Your Ref: OWPC3331
Our Ref: A/99/14/HH 20-07-2014
Please ask for:
Mr D Sullivan

Retention brickwork front boundary wall (resubmission following A/46/14/HH). This application affects the character and appearance of the Angmering Conservation Area.

2 Woodford Villas High Street Angmering

DRAWING TITLE
EXISTING FRONT BOUNDARY WALL
ELEVATIONS, PLAN AND SECTION

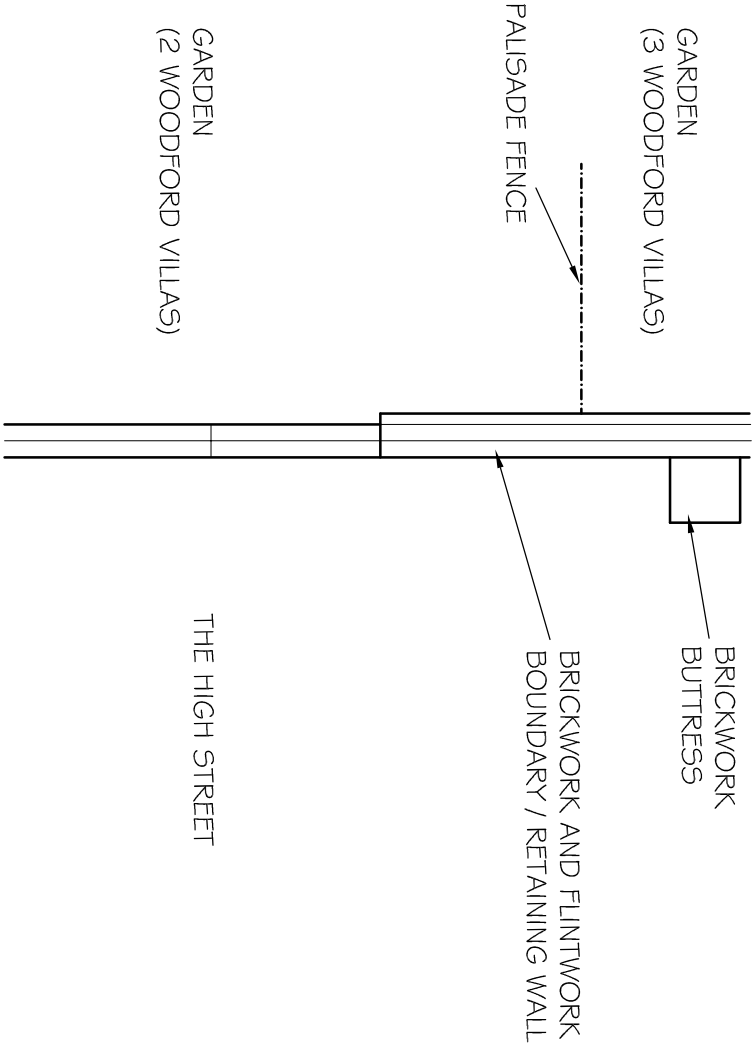
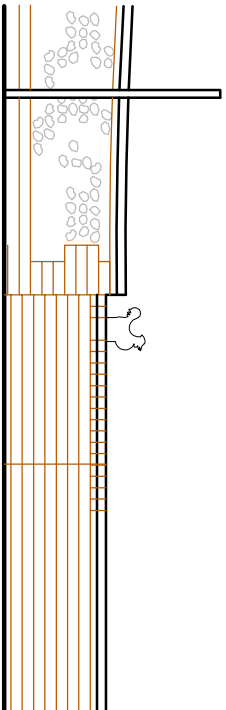
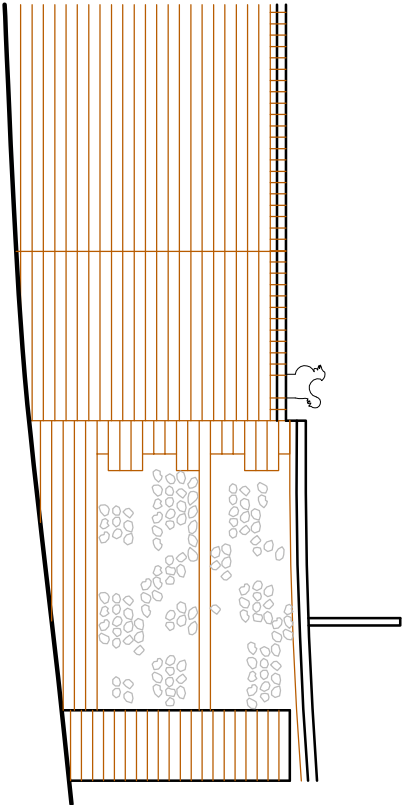
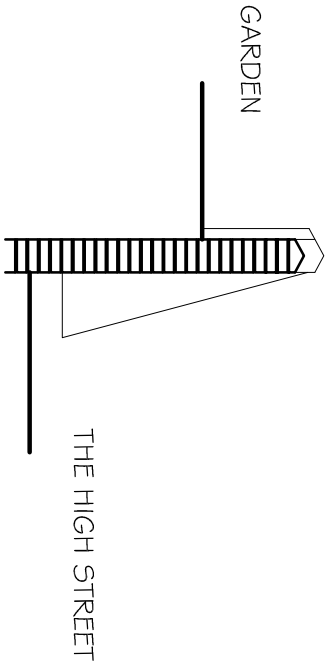
I am unhappy with the height and appearance of the wall. I would like the wall to be removed and the steps from the road reinstated.
